Lancashire Gardens Trust
Conservation & Planning Group

1 September 2022

Your ref: 3/2022/0623

Planning Application No: 3/2022/0623;
Proposed conversion of former stud farm stables to form part of residential dwelling and extensions to existing property; Woodfold Park Stud, Woodfold Park, Mellor, BB2 7QA. GT Ref: E22/0707.

sheet: proposed elevations

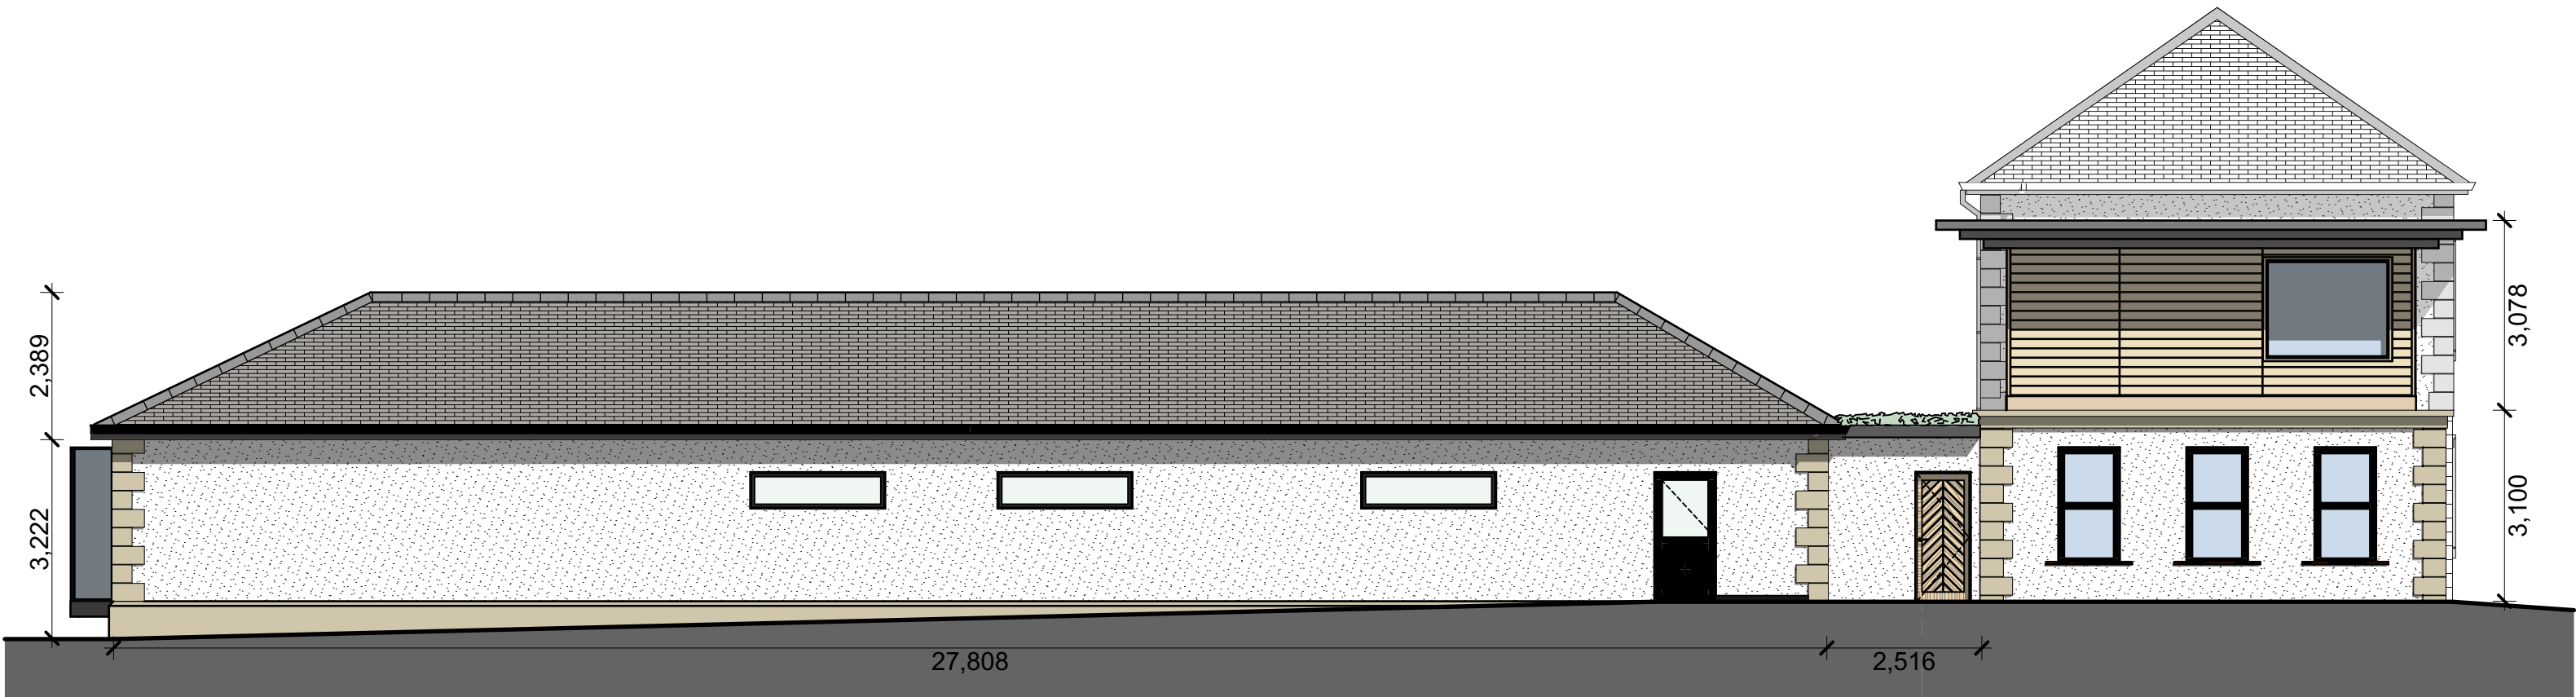
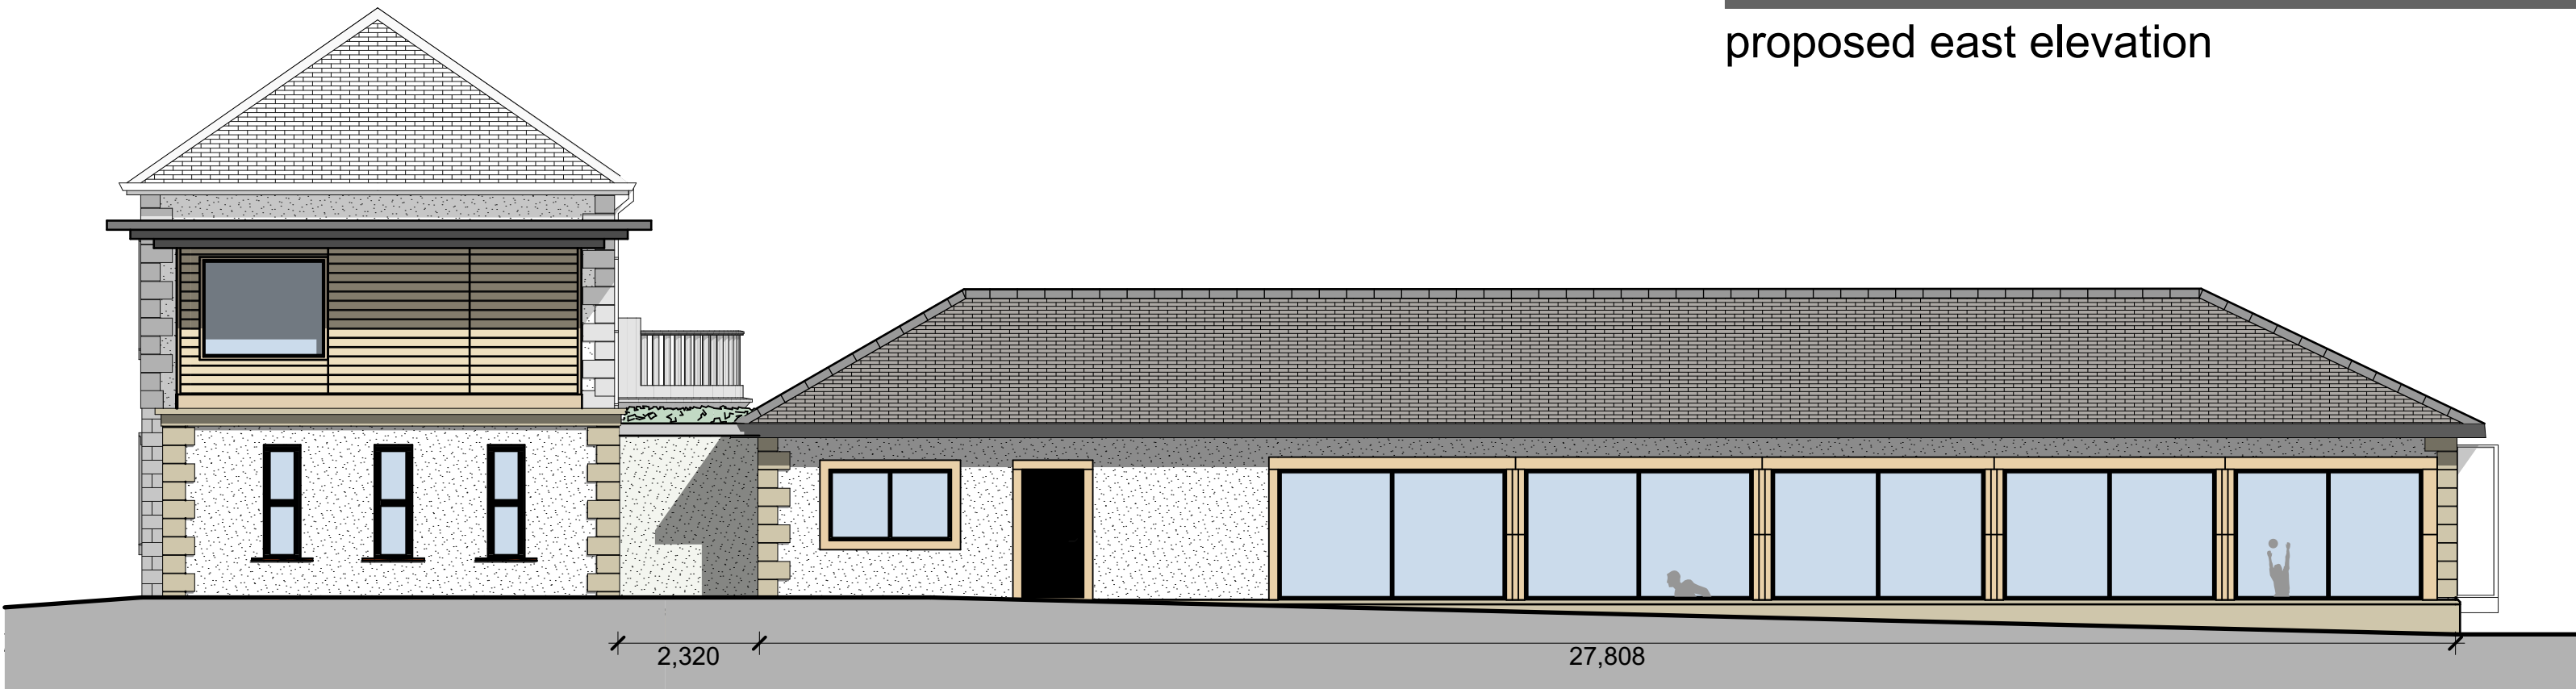
To enlarge the present residential property would compound damage already suffered to the RPG. The proposals are for an extended dwelling of nearly equal or larger scale than the historic Woodfold Hall, and where both can be viewed from within the Park. It is likely that both properties can be seen from the same viewpoints, but this should be clarified through a visual assessment.
